# CITY OF ALBUQUERQUE

**Re: Mirehaven Improvements Grading Plan  
Engineer's Stamp Date 4-15-14 (H09D017D)**

## COA

**Meeting Objective:** Discuss Mirehaven Arroyo Improvements Report and Plans

HEC-RAS PROFILE

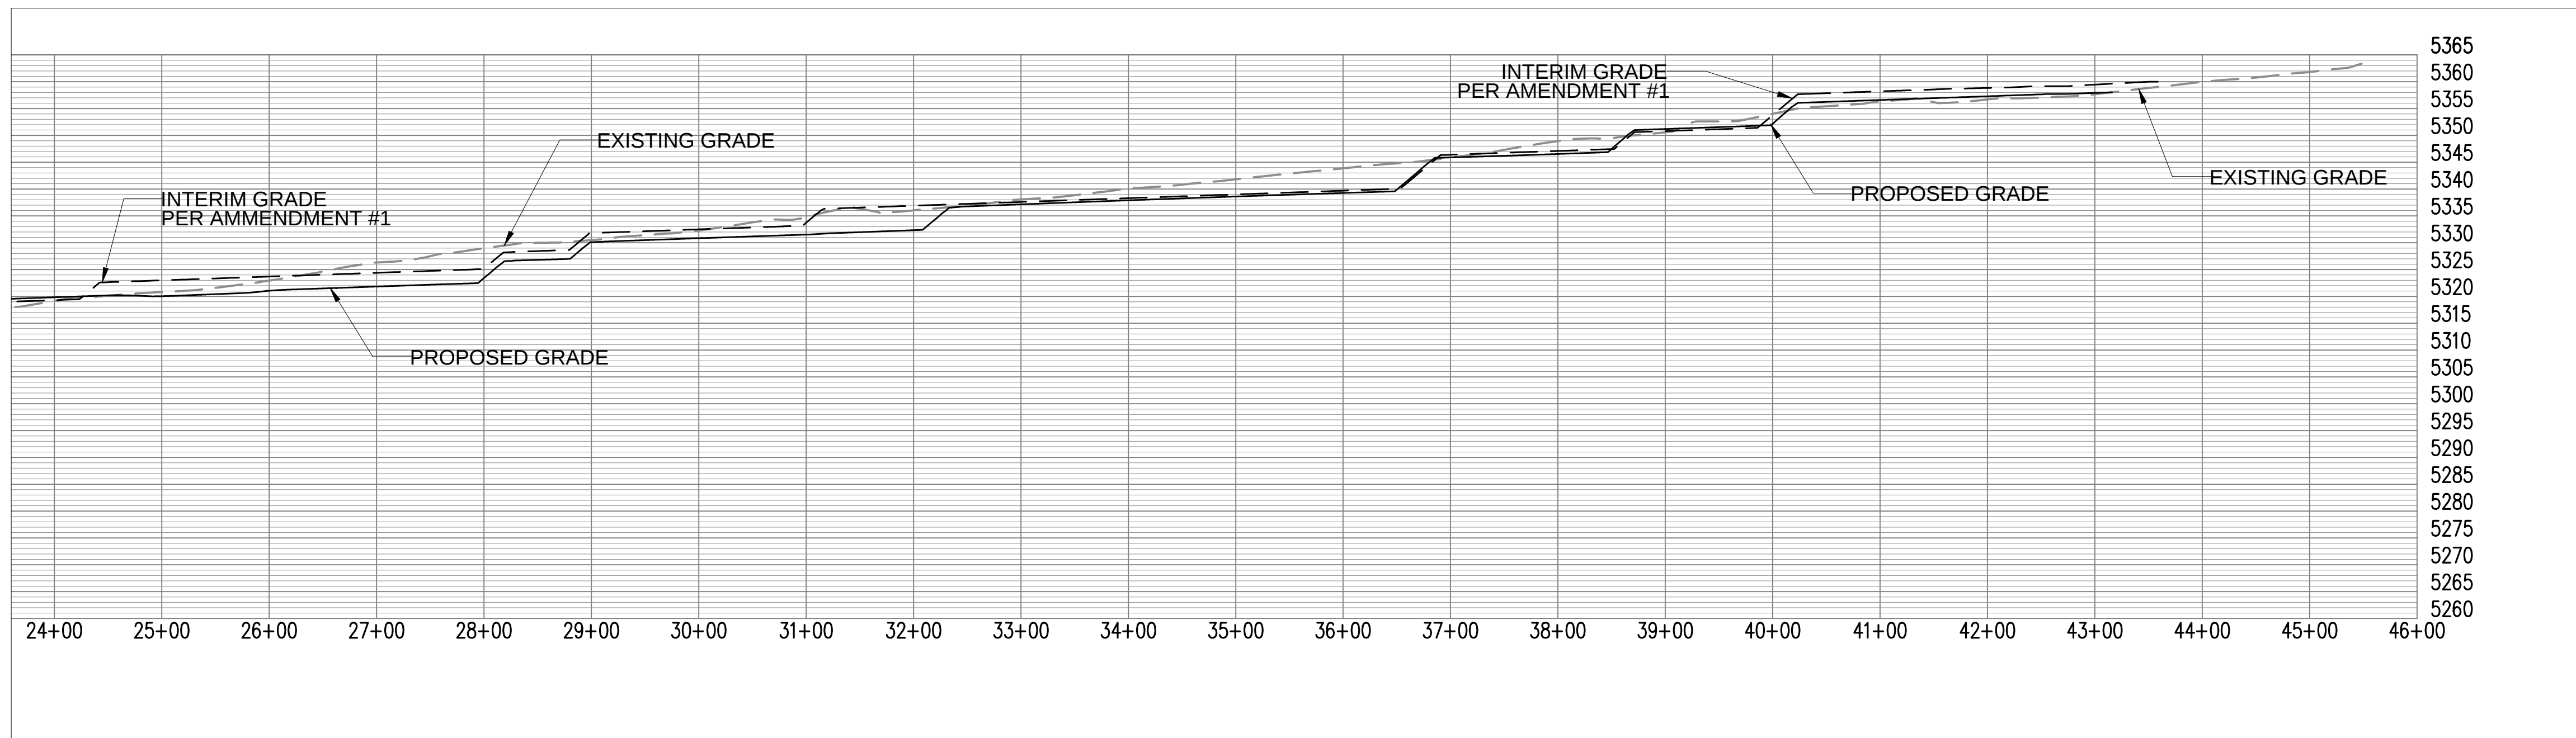
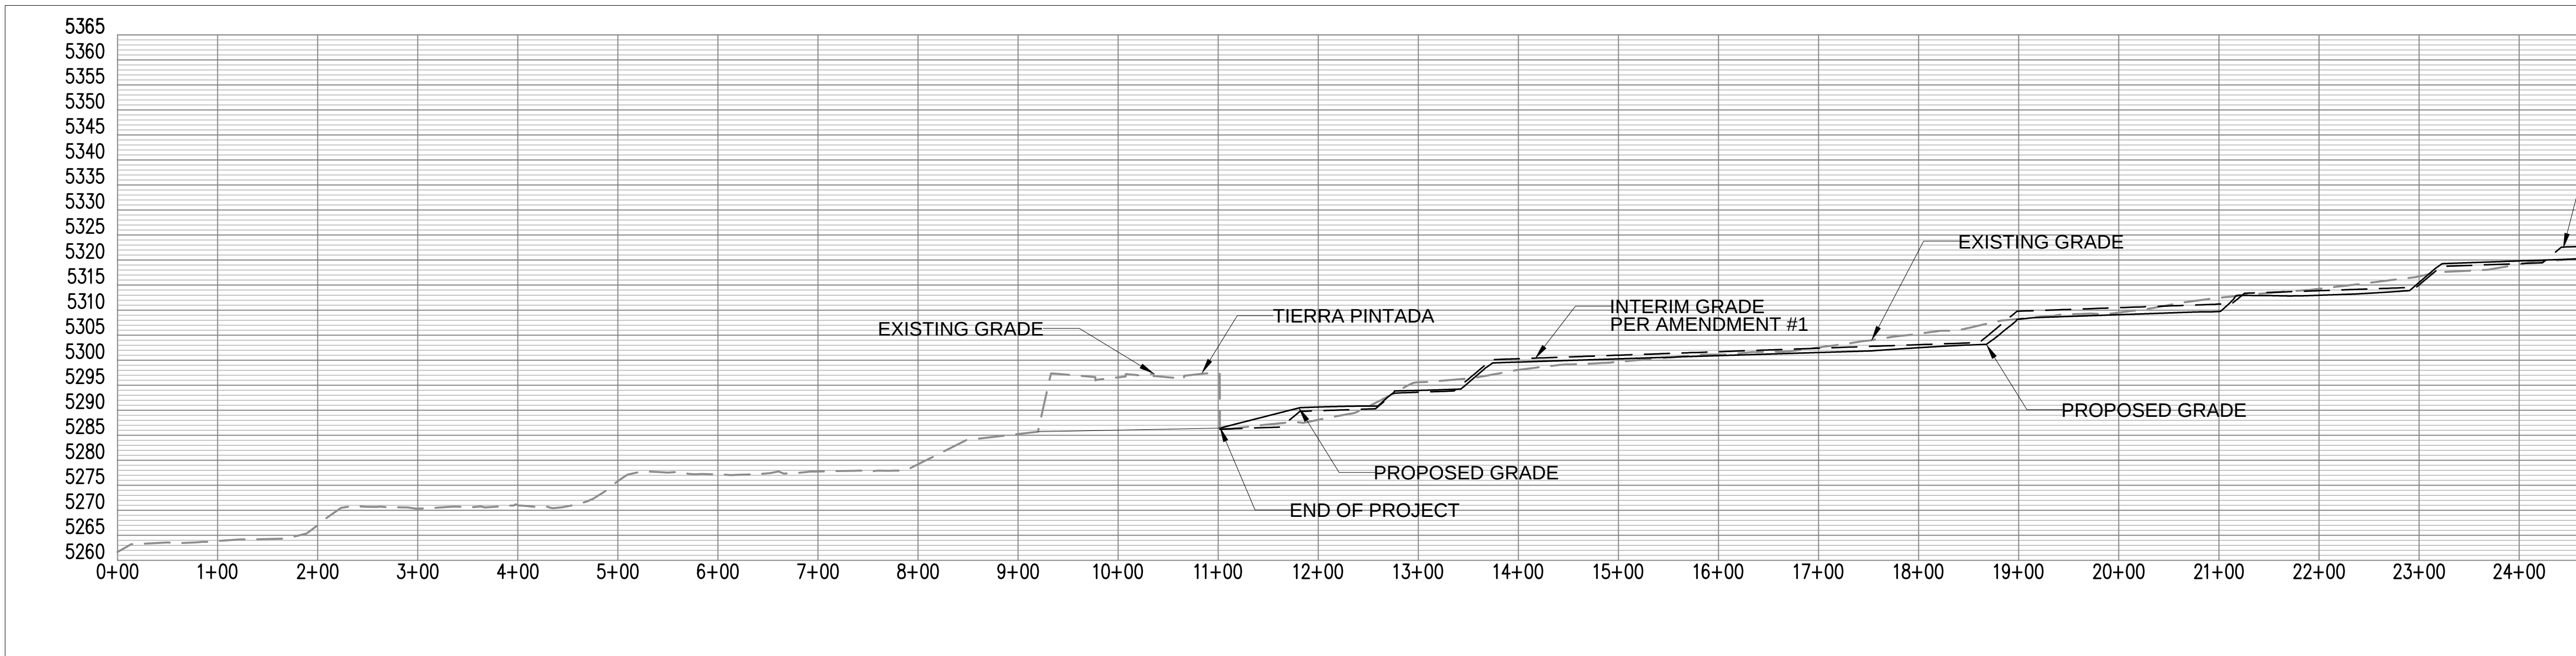
There was a general discussion on drop structures and the details of the final design. The final design reflects the drop heights and locations based on the easement boundary, the grade needed in the arroyo and the adjacent subdivision grades outside the arroyo. A profile with the proposed grades, the previous design grades, and the existing grades was reviewed.

The hydraulics of the channel and the existing culvert crossing at Tierra Pintada were reviewed. The final design does not adversely impact the hydraulics at Tierra Pintada, the headwater upstream and the velocities through culvert are about the same.

BHI will update and resubmit Addendum #2 to the DMP next week and send a set of plans along with it. The HEC-RAS profile at Tierra Pintada will be included along with full size copies of the exhibits.

MIREHAVEN ARROYO IMPROVEMENTS PLAN

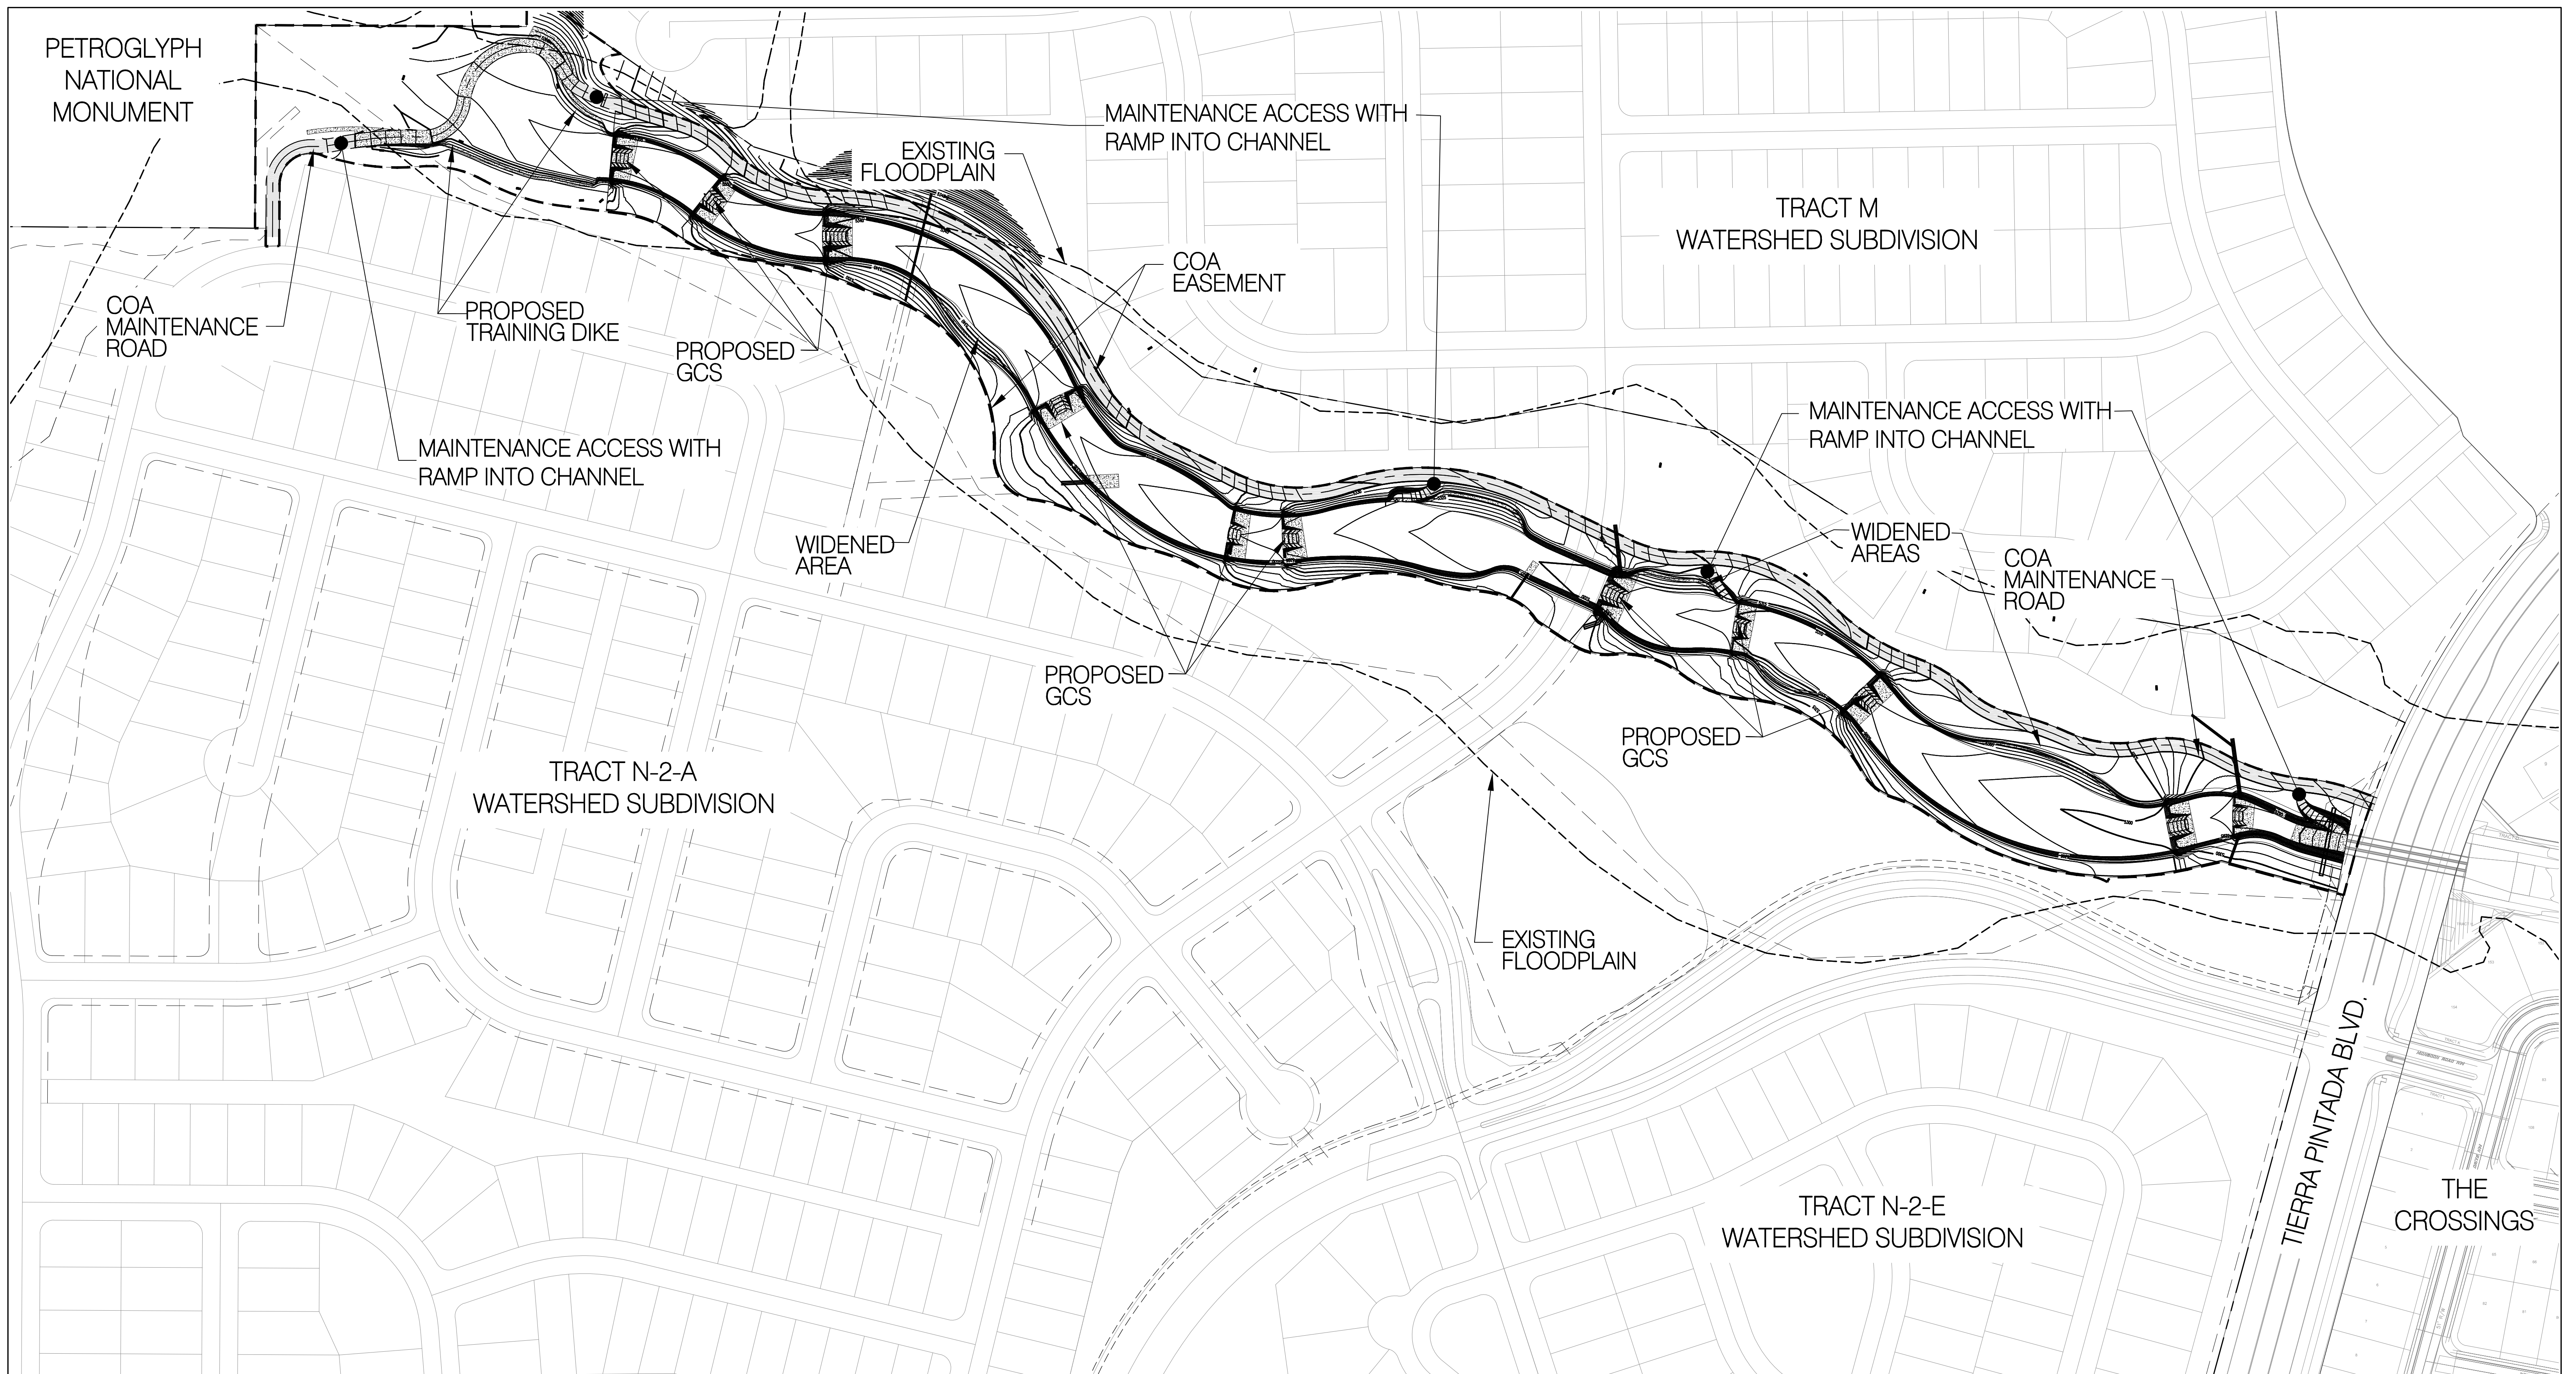
- As-built elevations for the storm drains that have already been constructed should be used.
- There has been evidence of scour near the storm drain outlets. The storm drains that come into the arroyos will be reviewed.

- BHI will review the waterline casing near to Tierra Pintada and make sure it extends beyond the shotcrete.
- BHI will review the cross section of the channel and maintenance ramp at the downstream end near Tierra Pintada.
